April 17, 2023

**Re: Galles Chevrolet Parking at 2001 Candelaria Rd. NE & Motel 1 Demo  
Erosion and Sediment Control Plan  
Engineer's Stamp Date 4/4/2023 (H15E007)**

Based upon the information provided in your submittal received 4/12/2023, the above referenced ESC Plan cannot be approved until the following comments are addressed.

Boundary Survey and ALTA/NSPS Land Title Survey

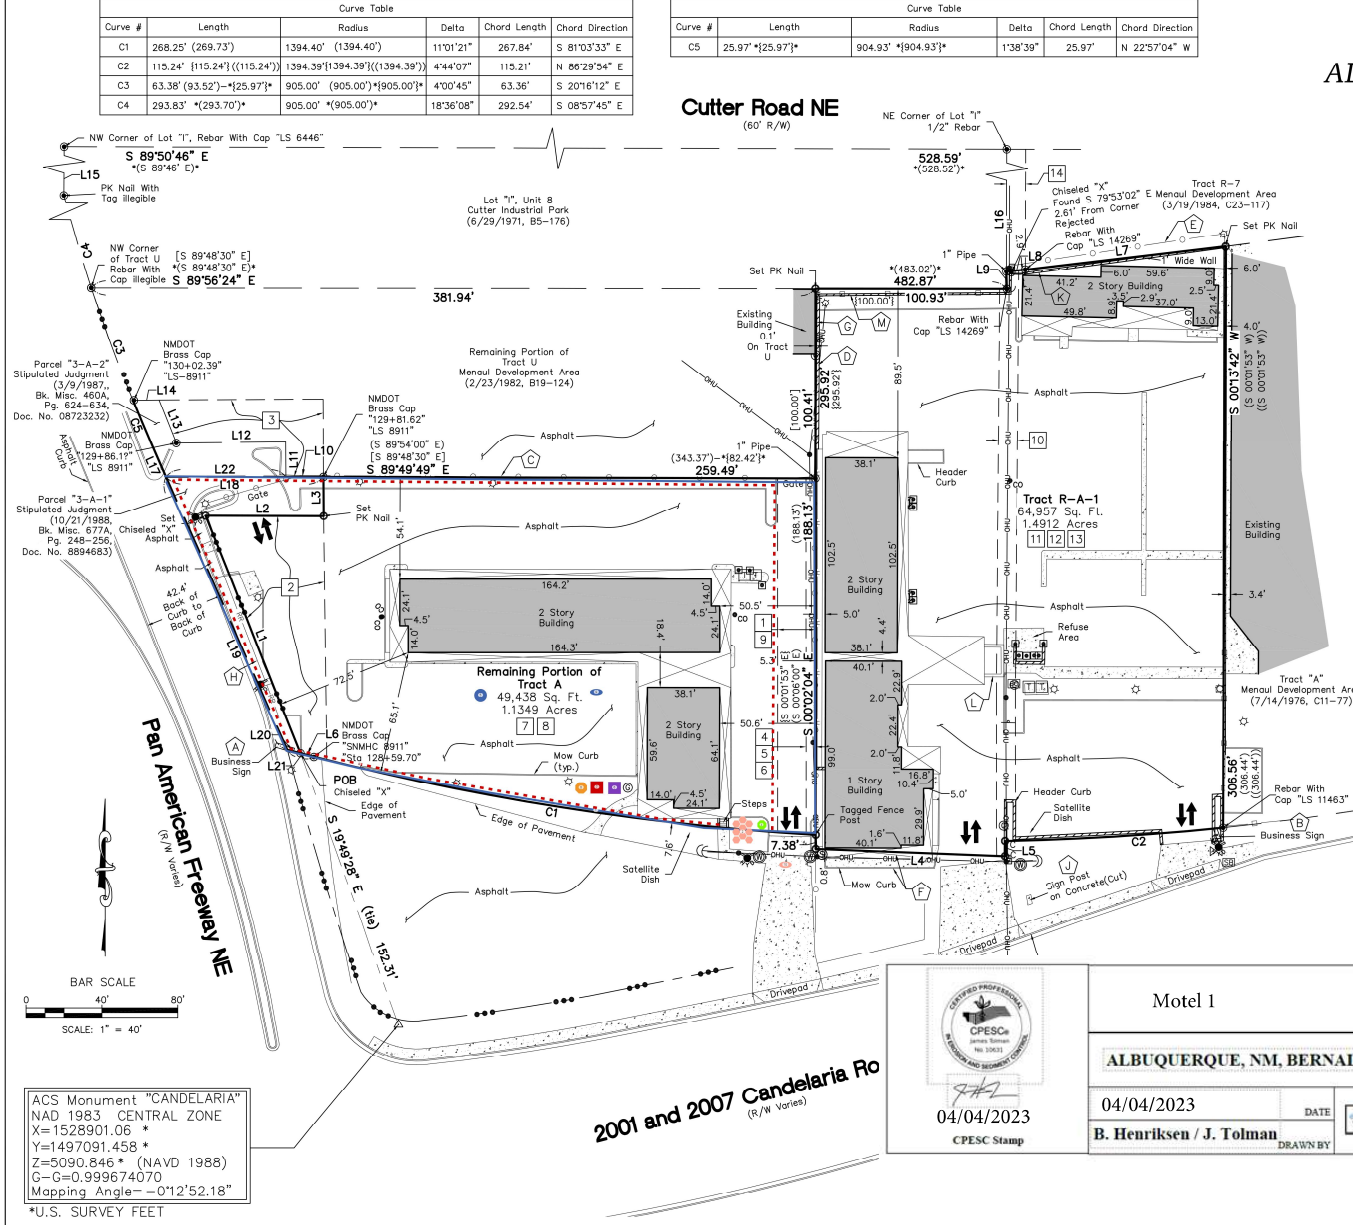
2. The ESC Plan can't be approved until after Hydrology approves the G&D Plan for each specific purpose, Grading Permit, Paving Permit, and/or Building Permit. The existing and proposed grades must be shown on the ESC Plan, and they must agree with the Grading Plan approved by Hydrology (CGP7.2.4.b.ii);

4. Structures, including buildings, sidewalks, and paving must be clearly identified in the SWPPP per CGP 7.2.4.b.vi. Show Galles's intended use of the site. The same information is required in the ESC Application. You may attach a copy of the Site Plan to both the SWPPP and the ESC Application to address this requirement.
